**WELWYN HATFIELD BOROUGH COUNCIL
EXECUTIVE DIRECTOR - PLANNING, PUBLIC PROTECTION AND GOVERNANCE**

Application No: 6/2021/0169/HOUSE
Location: 37 Sherrardspark Road Welwyn Garden City AL8 7JY
Proposal: Erection of a first floor side extension
Officer: Ms Emily Stainer

Recommendation: Granted

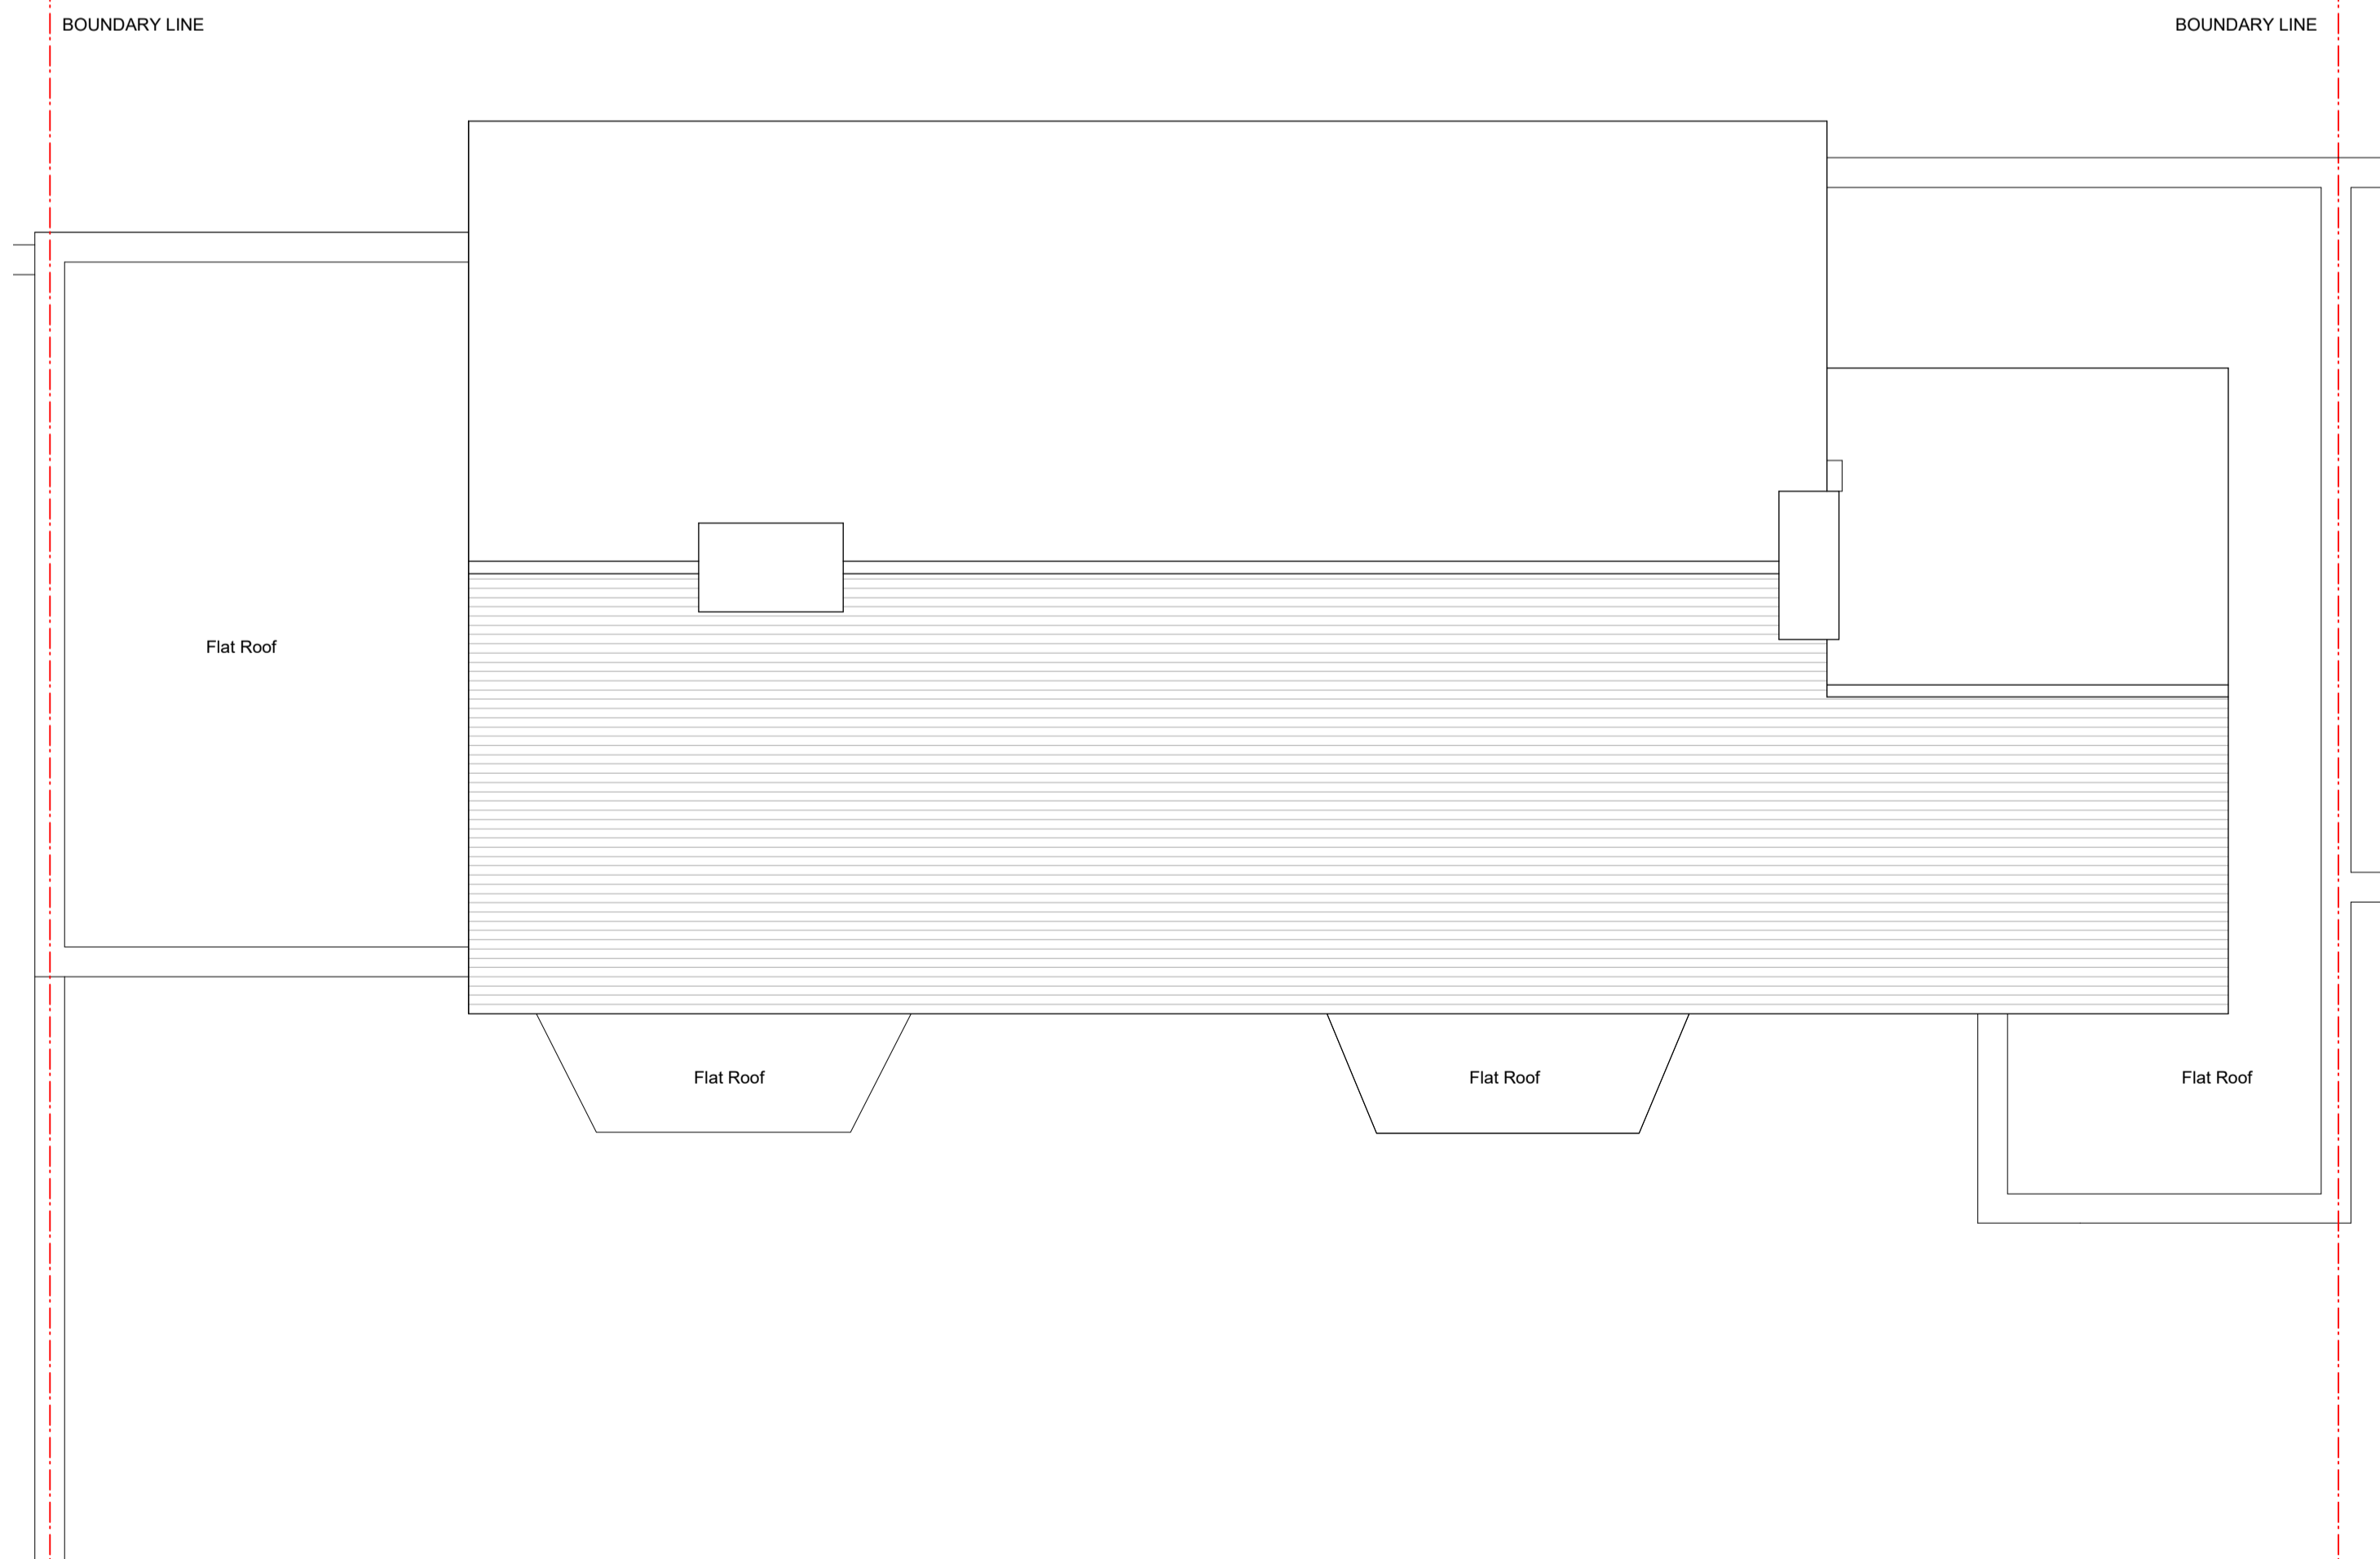
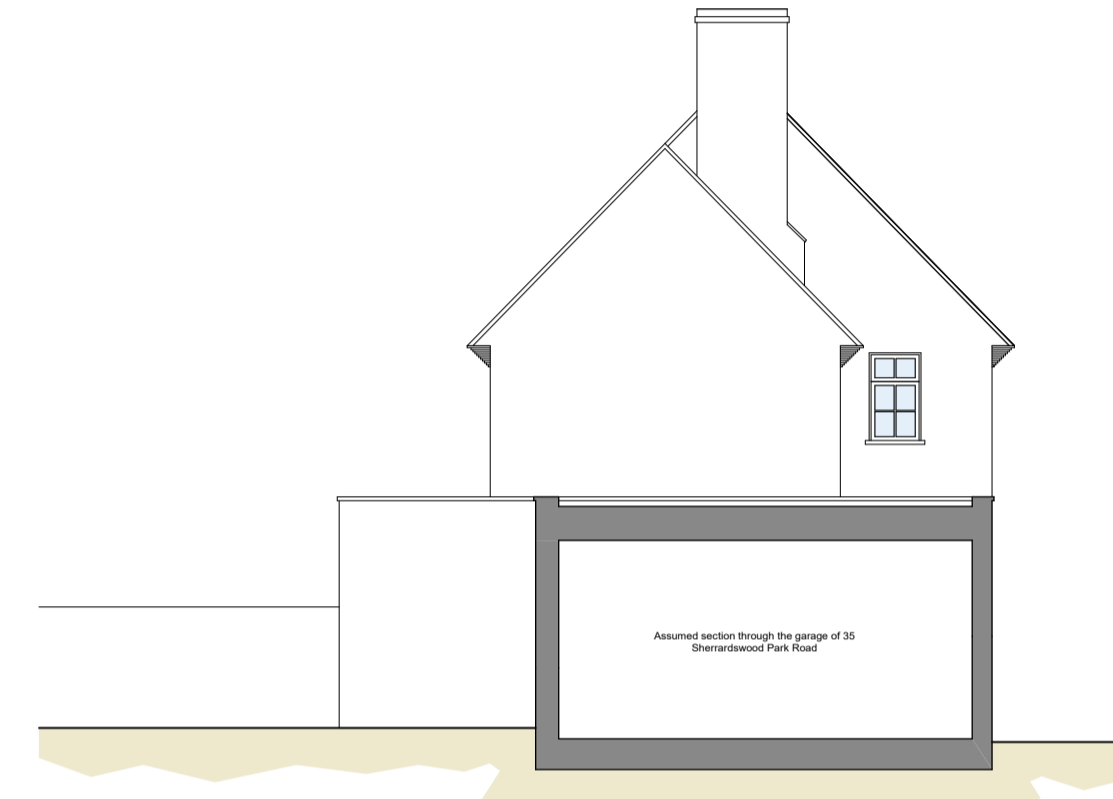
Sherrardspark Road typically consists of detached two storey redbrick housing dating from the 1950s onwards. Some properties do retain original features such as crittal windows and oak front doors. However, there are some original Louis de Soissons dwellings which date back to the 1920's/1930's. The proposed extension would leave a separation gap of approximately 1m between the flank wall and the common boundary with 35 Sherrardspark Road, however the overhang from the eaves and roof would reduce the gap to approximately 900mm. It would also be set back from the front elevation by approximately 2m and set down from the ridgeline by approximately 1m. The proposed extension would therefore appear adequately subordinated to the scale of the host dwelling.

The SDG states that for all multi-storey, two-storey and first floor side extensions, a minimum distance of 1m between the extension and the adjoining flank boundary must be maintained, however it is also noted that existing spacing in the street scene should be reflected which may result in larger distances being required. The reason for retaining existing spacing is to prevent over development across plot widths and a terracing effect within areas of detached and semi-detached properties, to ensure that the extension of a dwelling does not prejudice the ability of an adjacent occupier to extend without destroying any separation spaces that exist and to preserve the amenity of adjoining dwellings including those whose rear gardens adjoin the

<p>proposed extension.</p> <p>The wide gaps between the houses (created by the placement of the adjoining flat roofed garages) is a key feature of the Garden City design and anything that might infill those gaps, even in angled views, might detract from the established character of the area. The application property is located in a road where there are groups of differently designed dwellings, however substantial spaces between dwellings at first floor are commonplace. As such, the spacing makes an important contribution to the character and appearance of the Conservation Area.</p> <p>It is noted that there are examples of first floor/two storey side extensions in close proximity to the application site, namely 34 Sherrardspark Road and 41 Sherrardspark Road. Whilst the proposed extension would reduce the space between the property and the boundary of the site, the two storey flank wall of the neighbouring property at 35 Sherrardspark Road is situated a significant distance away from the boundary by virtue of its separation at ground floor via a single storey side extension and garage. As a result it is considered that appropriate spacing would still be retained in the streetscene as a result of the proposal, therefore on balance, the proposal is acceptable on these grounds.</p> <p>The extension would be finished with matching materials, which can be secured by way of planning condition.</p> <p>Taking these findings as a whole, the proposal would preserve the character and appearance of the Welwyn Garden City Conservation Area. Consequently, there is no conflict with Policy D1 of the Welwyn Hatfield District Plan 2005, which requires high quality design in new development.</p>

<p>Impact on neighbours</p>	<p>Policies D1, R19 and the Supplementary Design Guidance aim to preserve neighbouring amenity. In addition, the NPPF seeks to secure high quality design and good standard of amenity for all existing and future occupiers of land and buildings. No neighbour comments have been received.</p> <p>The Council's historic planning records have been consulted and demonstrate that the windows at first floor at 35 Sherrardspark Road that face the application property serve a bedroom and a staircase. Furthermore, a dormer window on the second floor serves a second staircase to the converted loft. The proposed extension would increase the amount of built form at the site and extend closer to the neighbour's boundary at 35 Sherrardspark Road, however a suitable separation distance would still exist to preserve the amenity of the adjoining occupiers. The bedroom window at first floor at 35 Sherrardspark Road is a secondary window to that room which also has a window facing the street, therefore it is considered that an appropriate outlook would still be obtained.</p> <p>It is not considered that any other neighbouring dwellings would be impacted as a result of the proposed first floor side extension.</p>

Landscaping Issues	The proposed extension would be at first floor and built over the existing garage. As it would be contained within the existing footprint of the property, there are no concerns raised regarding landscaping of the site.
Conclusion	
Subject to the imposition of a condition in respect of materials, the proposed development would be acceptable and would maintain the character and appearance of the existing dwelling, the street scene. It would also preserve the character and appearance of the Conservation Area in accordance with the requirements of S72 of the planning (Listed Buildings and Conservation Areas) Act 1990.

1. The brickwork, roof tile, bond, mortar, windows, detailing, guttering, soffits and other external decorations of the approved extension/alterations must match the existing dwelling/building in relation to colour and texture.

2. The development/works shall not be started and completed other than in accordance with the approved plans and details:
